**From:** [Ken Edwards](#)  
**To:** [Chace Pedersen](#)  
**Subject:** RE: CU-24-00001 Vantage Valley Properties - Notice of Application  
**Date:** Thursday, March 21, 2024 2:18:01 PM  
**Attachments:** [image001.png](#)

Vantage Valley Properties  
Permit#: CU-24-00001  
Date: 03/21/2024

SUBJECT: WDFW COMMENTS ON CU-24-00001 Vantage Valley Properties

**TO:** All Staff  
**FROM:** Public Works Plan Review Team  
**DATE:** April 5<sup>th</sup>, 2024  
**SUBJECT:** CU-24-00001 Vantage Valley Properties

CROSS VALLEY
 NATIONAL TRAINING
 CENTER
 SITE PLAN
 OCTOBER 9, 2023

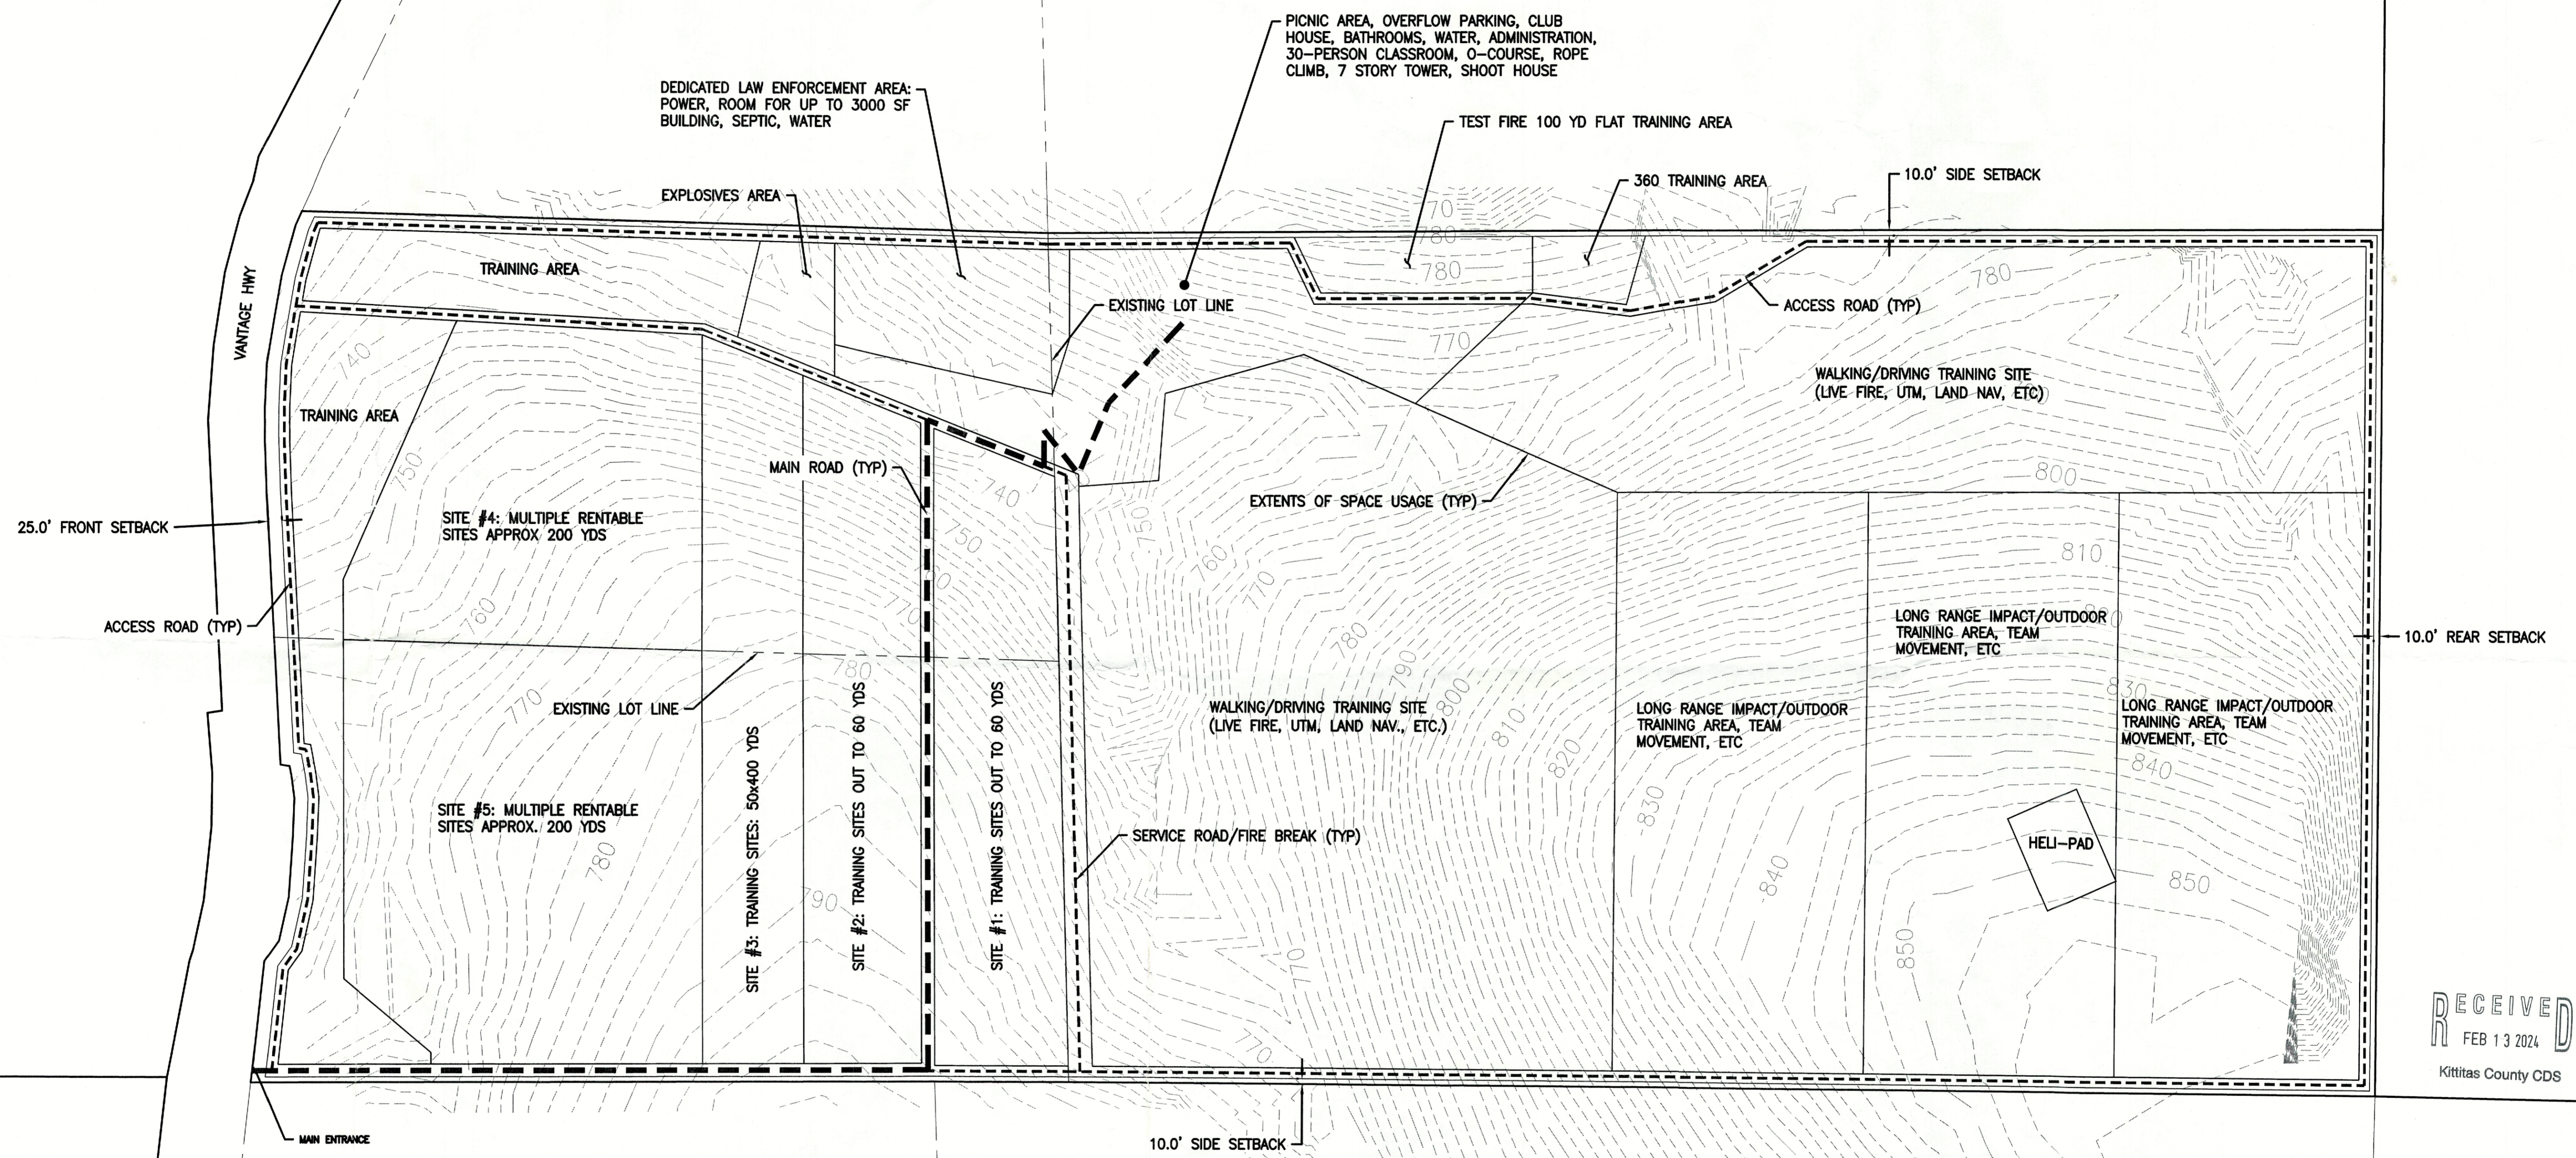
- As currently proposed, a minimum 10-foot setback from the western property boundary (which includes WDFW managed land) and proposals for explosives area, training areas, and test fires. Both wildlife and recreational visitors could be on either side of this boundary. The project needs to further demonstrate how these activities will not impact either the wildlife or the recreational users. The information currently provided in the SEPA checklist is incomplete to draw this conclusion. Potential modifications could include the need to increase the buffer distance from these activities (particularly in high-risk activities such as explosives), and the property line, add berms, and clearly mark the boundaries with proper warnings.

- In the northern portion of the site plan, a Heli-pad is proposed. As this area is a Mule Deer and Elk wintering area, consultation with WDFW is requested and proposed flight paths in and out of this Heli-pad need to be discussed to ensure the applicant is not displacing the animals away from vital winter forage, but also potentially displacing deer and elk into other properties or onto the Vantage Highway.

- Little detail is shown on the site plan, showing the direction of live fire, or proposed berms/backstops. Further the roads are shown as direct lines, yet the topography suggests that it will be difficult to construct due to the steepness of the grade. Please include WDFW in these discussions as the site plan and its associated impacts develop.

<b>ACCESS</b>	<ol style="list-style-type: none"> <li>1. Access is not permissible at the location on the site plan provided.</li> <li>2. An engineered access plan may be required.</li> <li>3. Provide Public Works with a plan for the guardrail that meets WSDOT requirements from a licensed civil engineer.</li> <li>4. An approved access permit for commercial access shall be required from the Kittitas County Department of Public Works prior to creating any new driveway access or altering an existing access.</li> <li>5. Driveways and Roads greater than 150' in length are required to provide a fire apparatus turnaround that is in compliance with Appendix D of the International Fire Code.</li> <li>6. Per Kittitas County Code, only one access is permitted. A Road Variance application will need to be applied for if 2 accesses are built. Road Variance does not guarantee second access.</li> <li>7. In addition to the above-mentioned conditions, all applicable Kittitas County Road Standards apply.</li> </ol>
